Recommendation Report for Planning Permission for Works or Extension to a Dwelling

REF NO: M/141/21/HH

LOCATION: Briarfield
Ancton Lane
Middleton-On-Sea
PO22 6NL

PROPOSAL: Erection of two storey rear extension, front porch extension, installation of 1 x side dormer and alterations to fenestration following the demolition of existing rear conservatory.

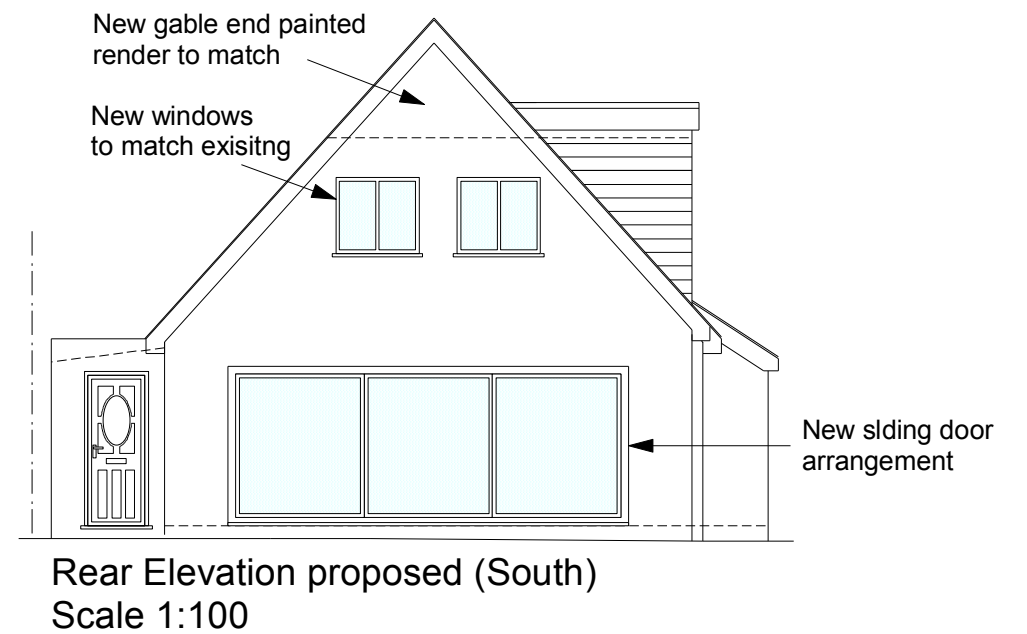
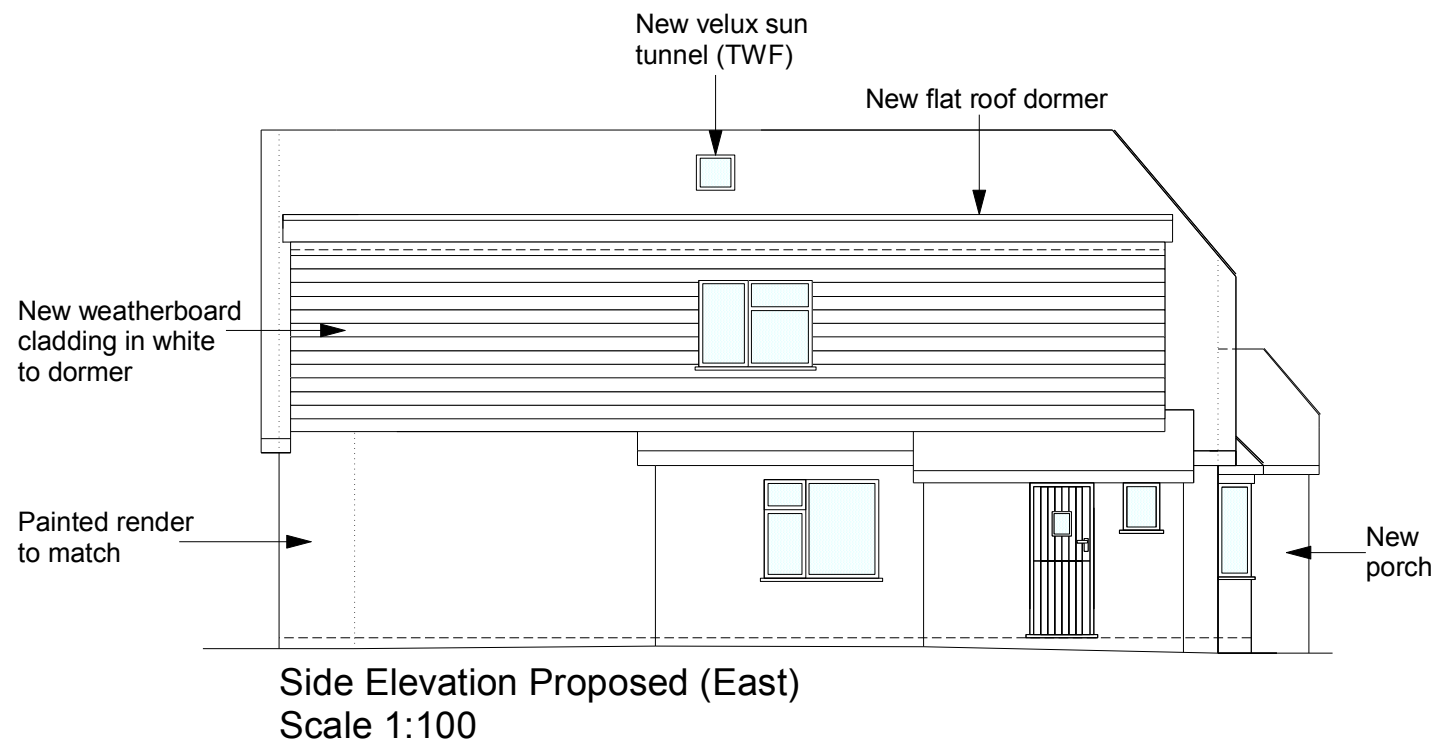
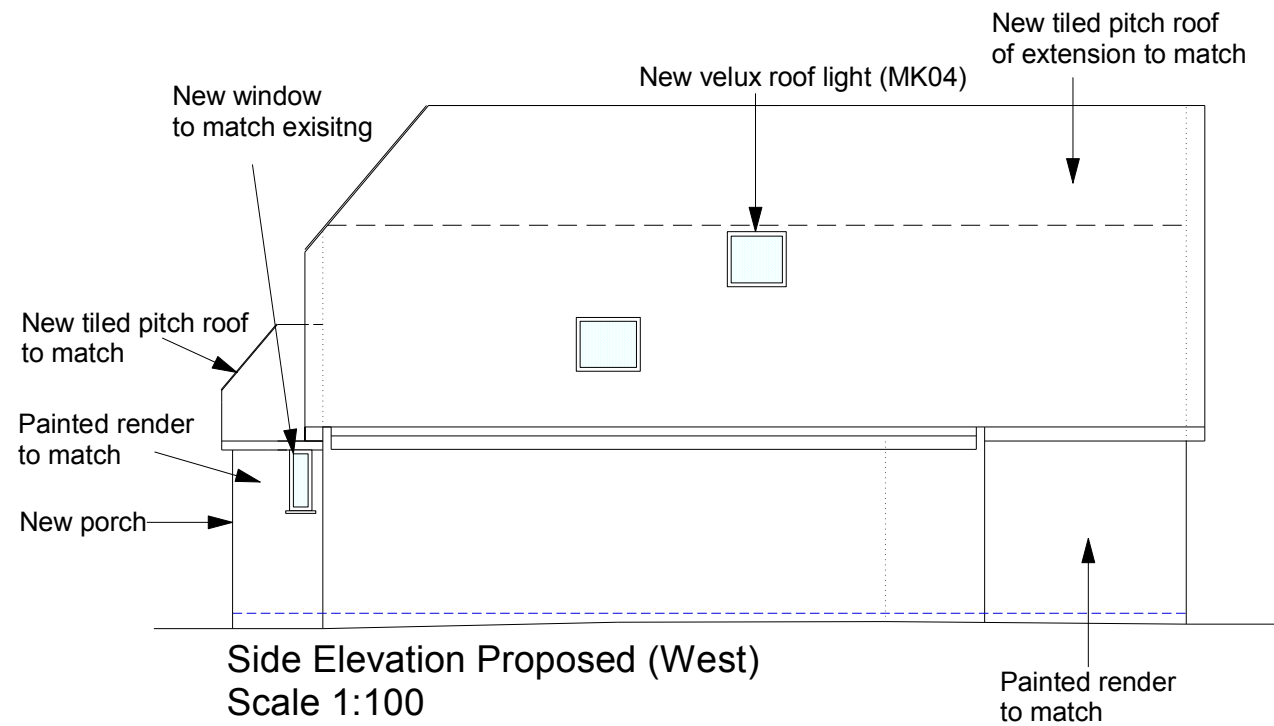
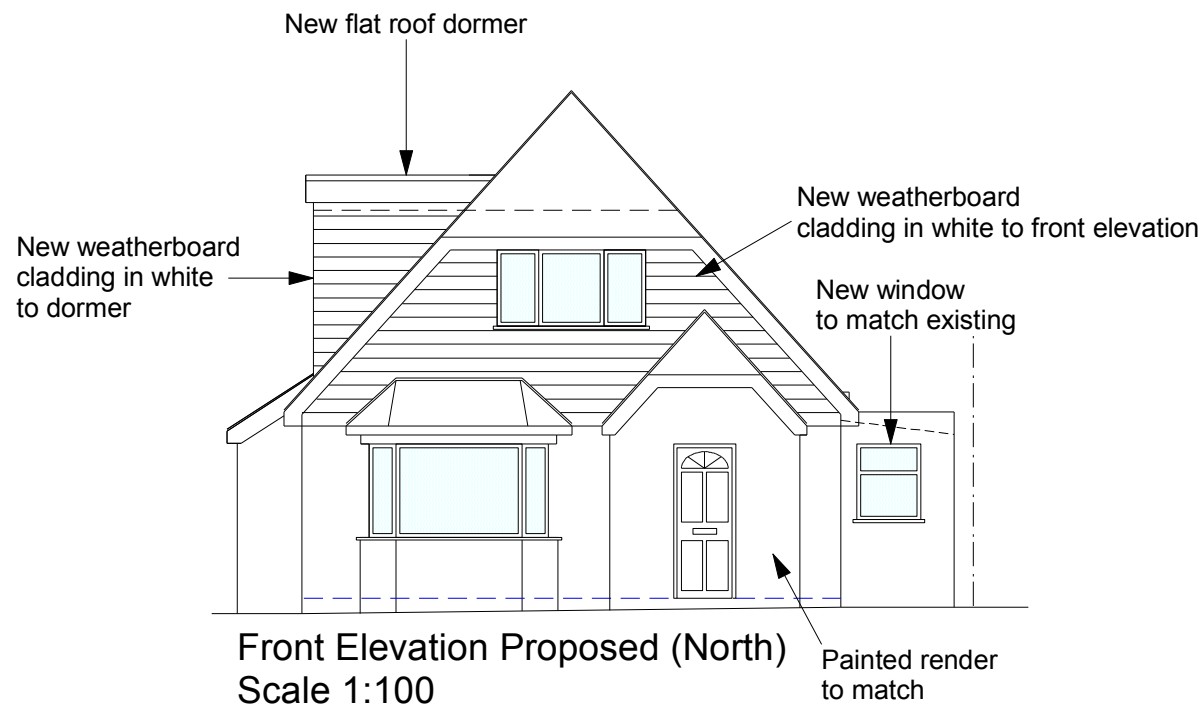
The proposed first floor extension would be located to the rear of the existing dwelling and a new dormer added to the east side of the roof. The extension would project 3m beyond the rear elevation of the original part of the dwelling and would retain a gap of 1.75m to the side boundary. The design guide class M encourages the set back and gap from the boundary to avoid any terracing effect. In this case the extension would be aligned with the main dwelling and roof profile to match the height of the existing ridge line. The design of the extension would not alter the roof profile and the side dormer although visible from the site frontage would not dominate the appearance of the dwelling and would appear subservient.

The front extension is minor in nature and although readily visible in the street scene would be assimilated into the existing dwelling. Materials of the extension would match the host dwelling and incorporate new white weatherboard cladding. The development accords with D DM1 and D DM4 of the Arun Local Plan.

the detached nature of the plot and the distance retained to site boundaries (1.75m to The Bays to the west and 3.5m to Cherrybank to the east). Although the extension projects 3m to the rear at first floor level it accords with the 45 degree rule. The side facing dormer is 3.5m from the boundary and includes a bedroom window which is conditioned to be obscure glazed below 1.7m internal floor height to ensure no adverse overlooking results to Cherrybank which has a secondary hall/staircase window in the existing side elevation. In addition the provision of additional windows is excluded by condition. The additional roof light on the western side serves a bathroom and is located within the roof area.

- 4 The bedroom window in the west facing dormer shall at all times be glazed with obscure glass and fixed to be permanently non opening below 1.7m internal floor height.
